Rosefield Solar Farm

Schedule of Changes to the draft DCO (Clean)

EN010158/APP/8.1.9
Revision 09
Deadline 7
August 2026
Rosefield Energyfarm Limited

## Streets, Rights of Way and Access Plans

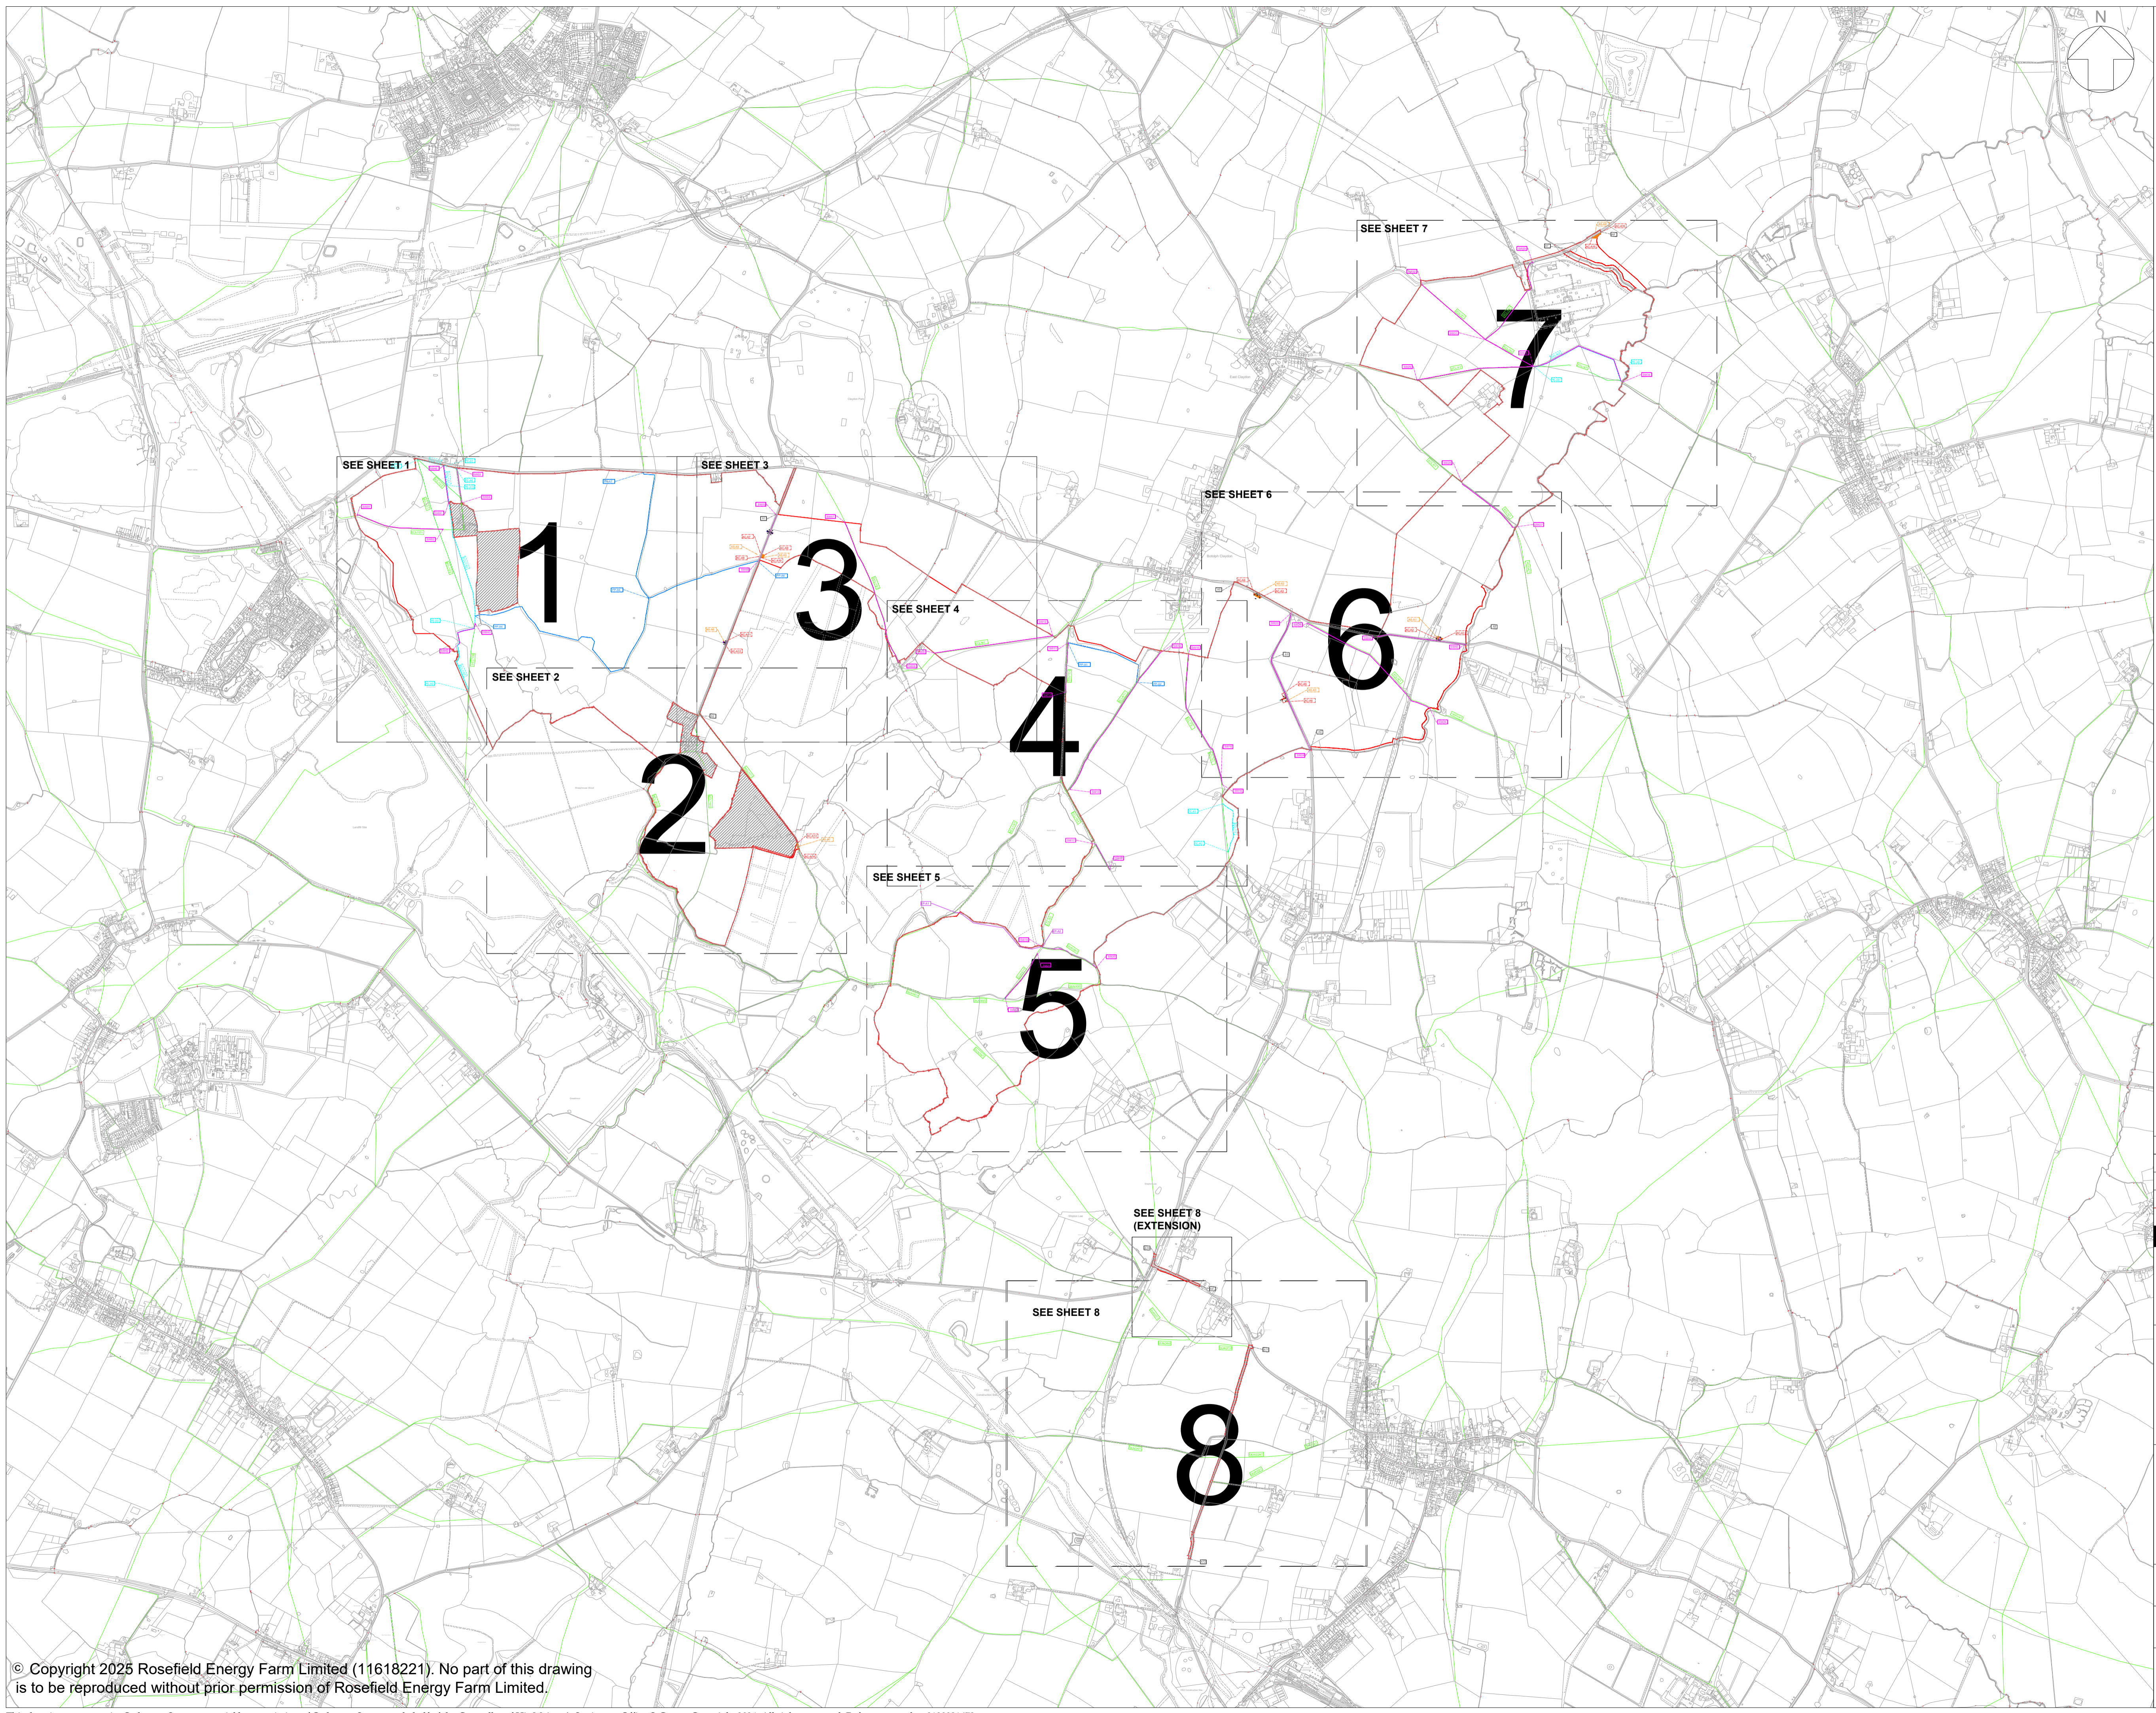
<table><tr> <th>(1) <i>Area</i></th><th>(2) <i>Public right of way to be stopped up</i></th><th>(3) <i>Extent of stopping up</i></th><th>(4) <i>New public right of way to be substituted / provided</i></th></tr><tr> <td>District of Buckinghamshire</td><td>SCL/13/1 and SCL/13/2</td><td>For a distance of 1,210 metres between points PE-A7 and PE-A3 as shown on sheet 1 of the streets, access and rights of way plans.</td><td>New public footpath of minimum width of 2m to be provided between points PE-A7, PE-A5 and PE-A4 and PE-A3 as shown by a cyan line on sheet 1 of the streets, rights of way and access plans.</td></tr><tr> <td>District of Buckinghamshire</td><td>SCL/12/2</td><td>For a distance of 190 metres between points PE-A7 and point PE-A10 as shown on sheet 1 of the streets, access and rights of way plans.</td><td>New public footpath of minimum width of 2m to be provided between points PE-A7, PE-A5 and its intersection with SCL/12/1 as shown by a cyan line on sheet 1 of the streets, rights of way and access plans.</td></tr></table>

Reference	Change				Reason for Change	Deadline
	District of Buckinghamshire	ECL/7/2	For a distance of 243 metres between points PE-A1 and PE-A2 as shown on sheet 4 of the streets, access and rights of way plans.	New public footpath of minimum width of 2m to be provided between points PE-A1 and PE-A2 as shown by a cyan line on sheet 4 of the streets, rights of way and access plans.		
	District of Buckinghamshire	ECL/4/2	For a distance of 463 metres between points PE-A8 and PE-A9 as shown on sheet 7 of the streets, access and rights of way plans.	New public footpath of minimum width of 2m to be provided between points PE-A8 and PE-A9 as shown by a cyan line on sheet 7 of the streets, rights of way and access plans.		
Schedule 16, 2(1) (Applications made under requirement)	For an application for discharge of a requirement to be valid, the undertaker must provide the following information to the relevant planning authority electronically via email (unless otherwise agreed between the parties in writing)—				The below updates to Schedule 16 have been made in response to comments in Buckinghamshire Council's Local Impact Report [REP1-112] and following further engagement with the Council following ISH1. Amendments reflect the approach	4
